Subject: Major Projects – Response to Submissions – Seniors Housing – IRT Woonona Redevelopment (SSD- 73910208) (Wollongong City)

Attachment A - CPHR Comments on Seniors Housing – IRT Woonona Redevelopment (SSD- 73910208) (Wollongong City) – Response to Submissions

FIGURE F52

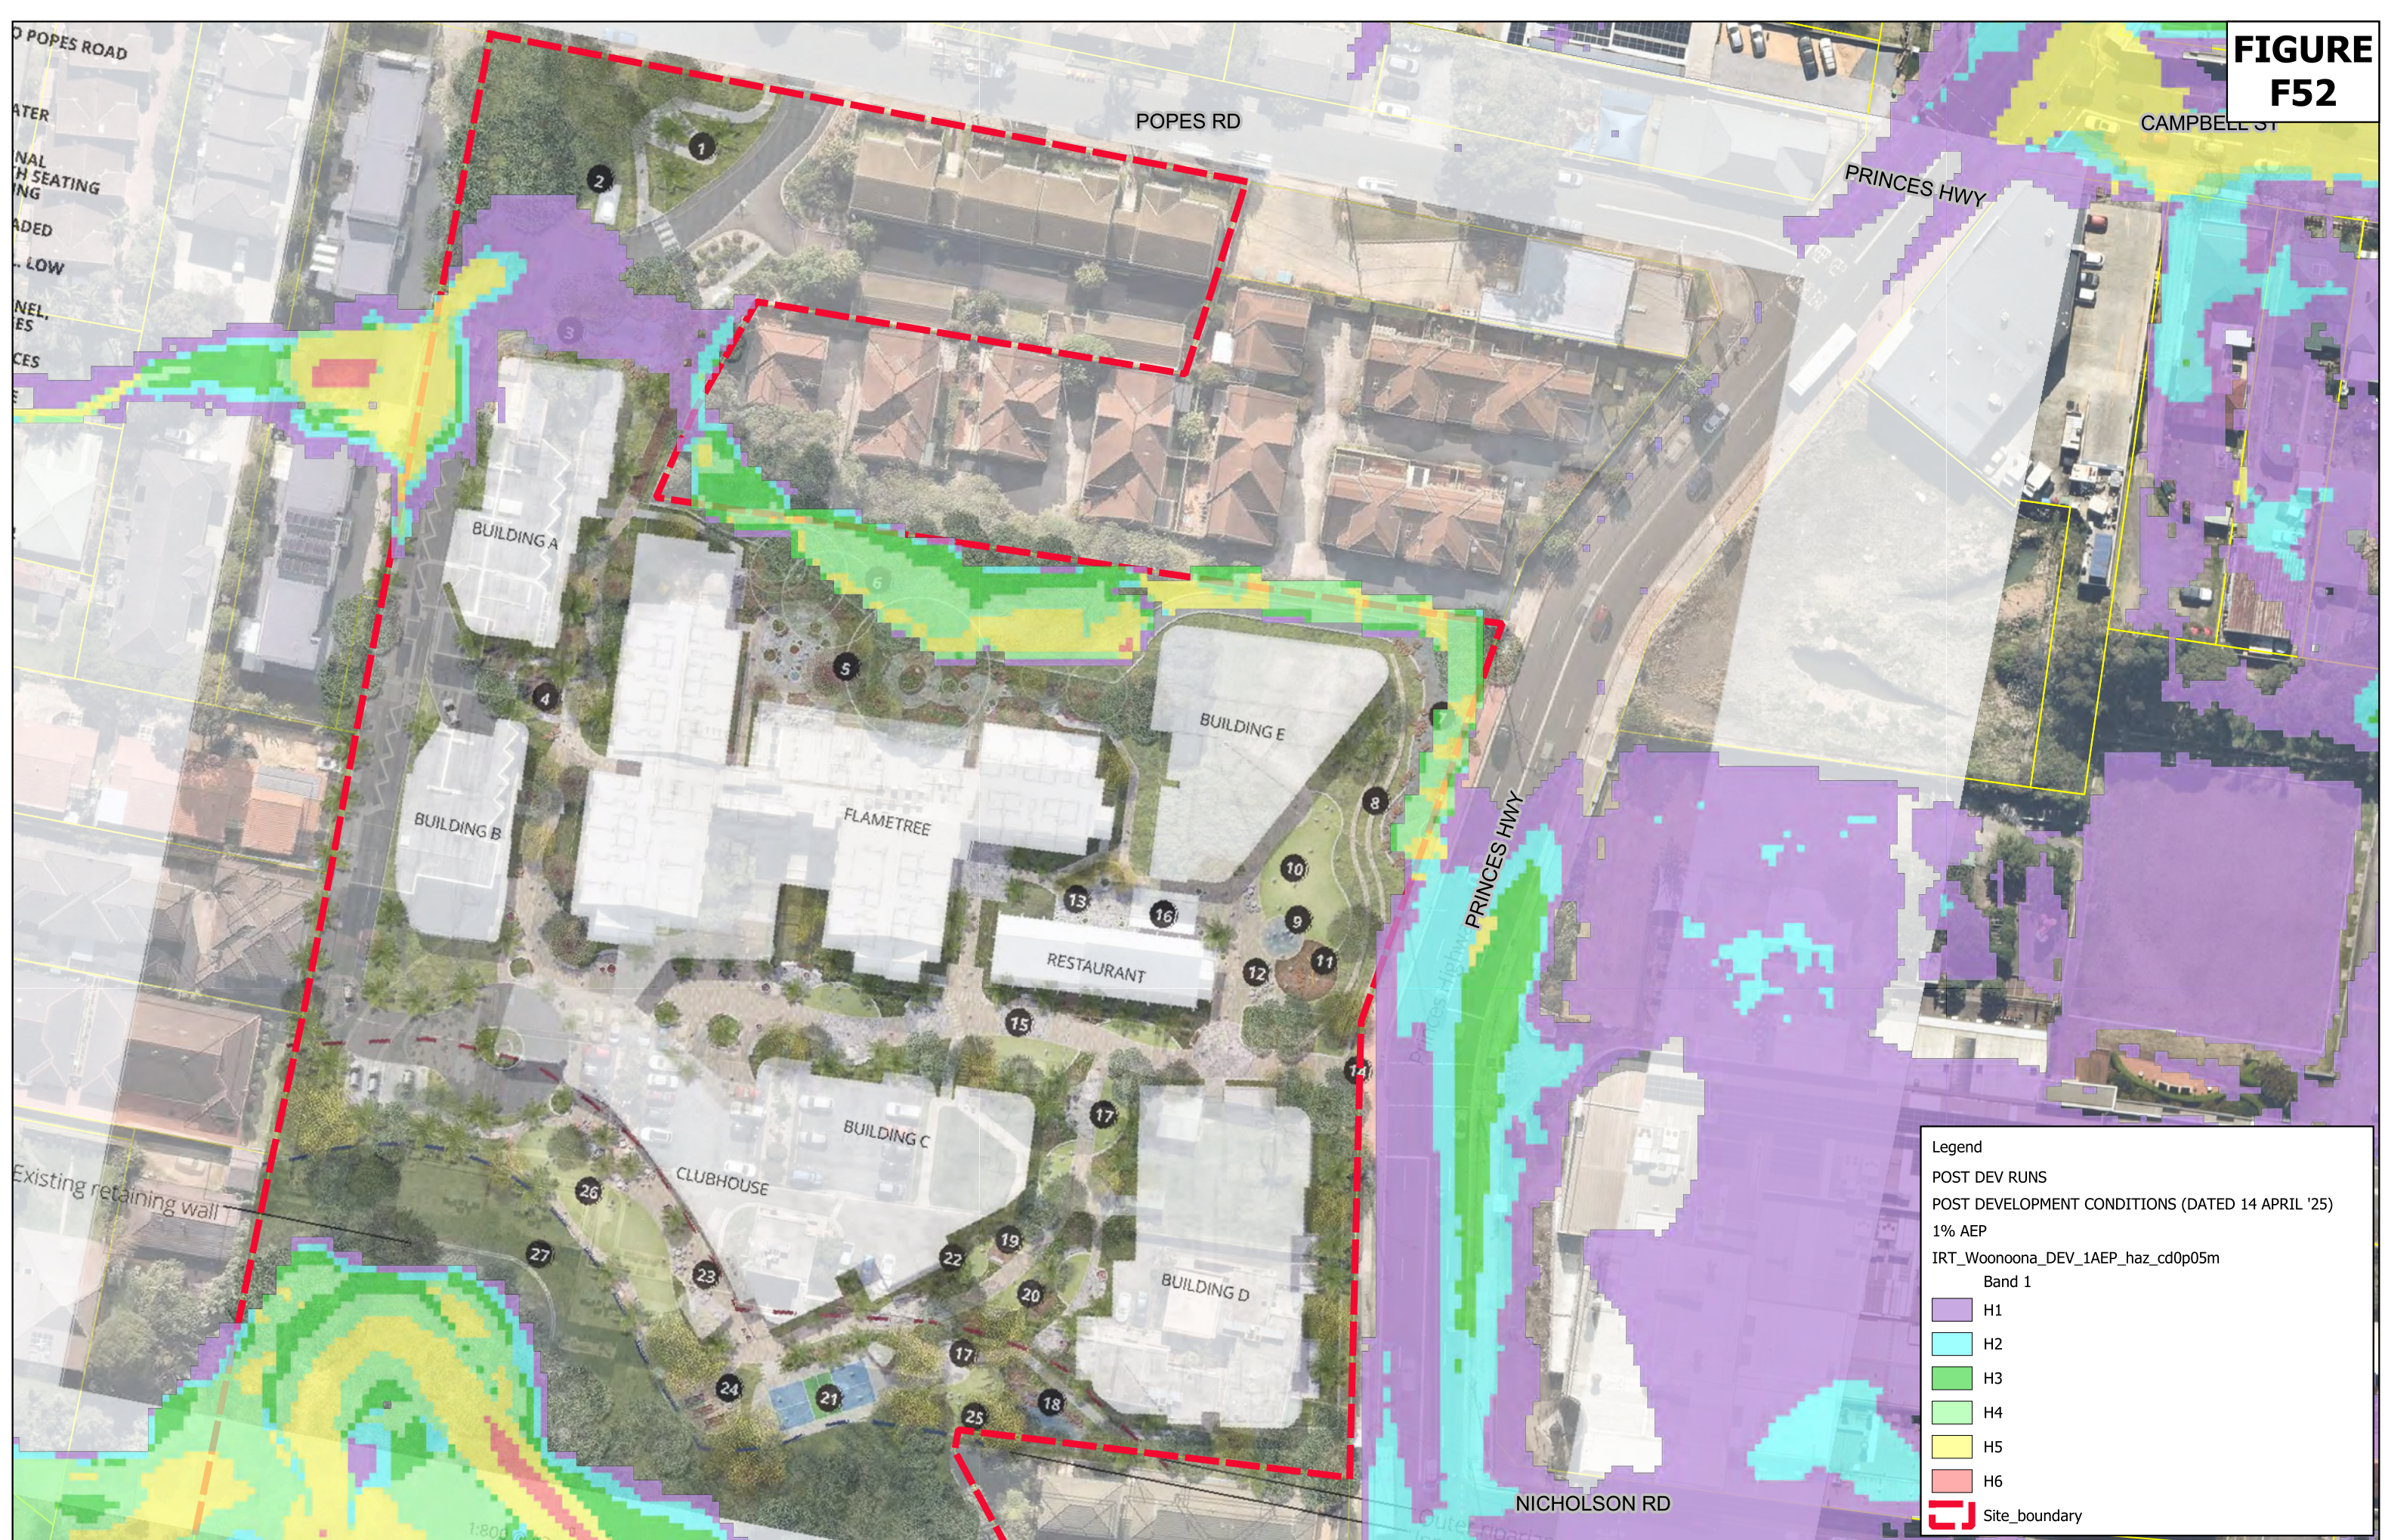
<p>CPHR Issue 2</p>	<p>Flooding</p> <p>The Flood Impact Risk Assessment maps provided in the initial Flood Report identified adverse flood impacts on Nicholson Road and Collins Creek in the 20% AEP event, and on the Princes Highway from the 10% AEP. The revised report indicates improved PMF levels with reduced impacts on proposed buildings.</p>
<p>Recommendation</p>	<p>Work with Wollongong City Council on managing its identified flood risk issues on site and consult with NSW SES on the final Flood Emergency Response Plan (FERP).</p>
